From: Sarah Hufford [REDACTED]
Sent: 18 September 2018 16:45
To: Simon Davis
Cc: Conservation Officer; Planning.Responses
Subject: RE: BR/204/18/PL & BR/203/18/L - Bath House, The Steyne, BR

From: Sarah Hufford
Sent: 18 September 2018 16:41
To: 'Simon Davis' <Simon.Davis@arun.gov.uk>
Cc: 'Conservation Officer' <Conservation.Officer@arun.gov.uk>; 'planning.responses@arun.gov.uk' <planning.responses@arun.gov.uk>
Subject: RE: BR/204/18/PL & BR/203/18/L - Bath House, The Steyne, BR

PROPOSED PLAN AND SECTIONS
FLAT 6

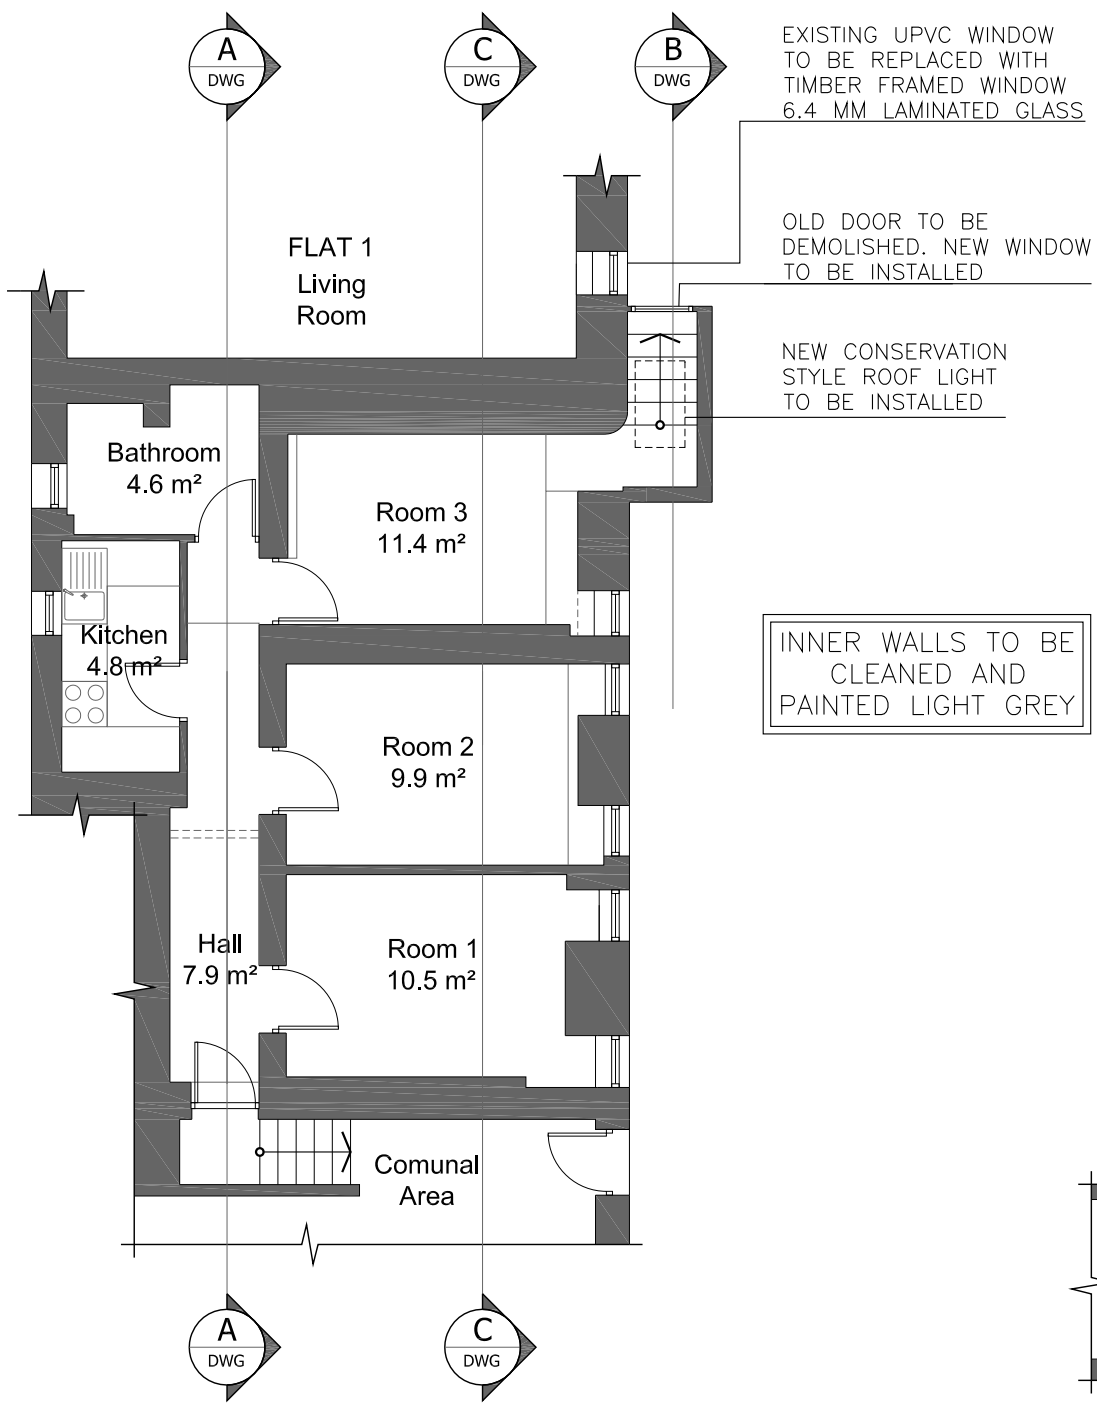
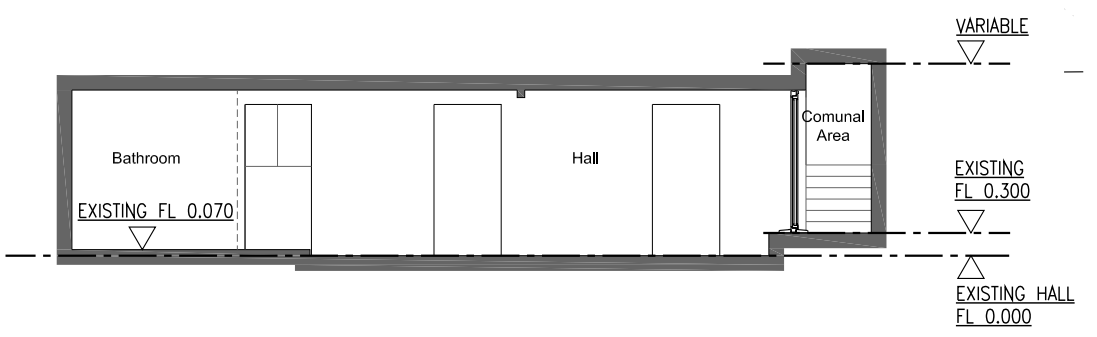
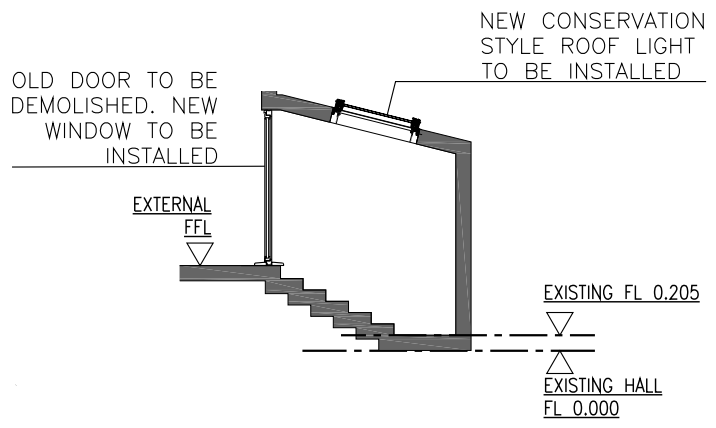
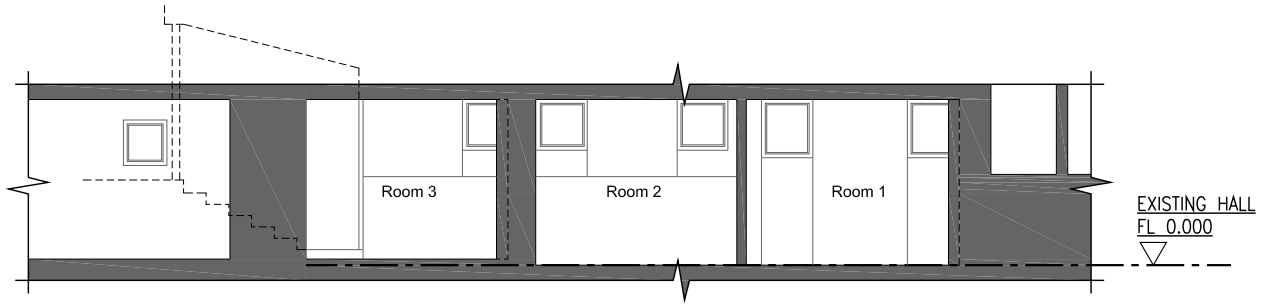
The side passage is visible from the Steyne and the proposed replacement window and masonry is considered will have a positive impact. However, it is not clear what the proposed windows will look like and details will need to be provided by way of condition. It is considered that the proposed windows will not be visible from the conservation area, and not cause any harm.

In response I attach Plan 104B to replace 104A.

This clarifies the proposed window [in place of the door] as a new three quarter height timber vertical sash window with panel window.
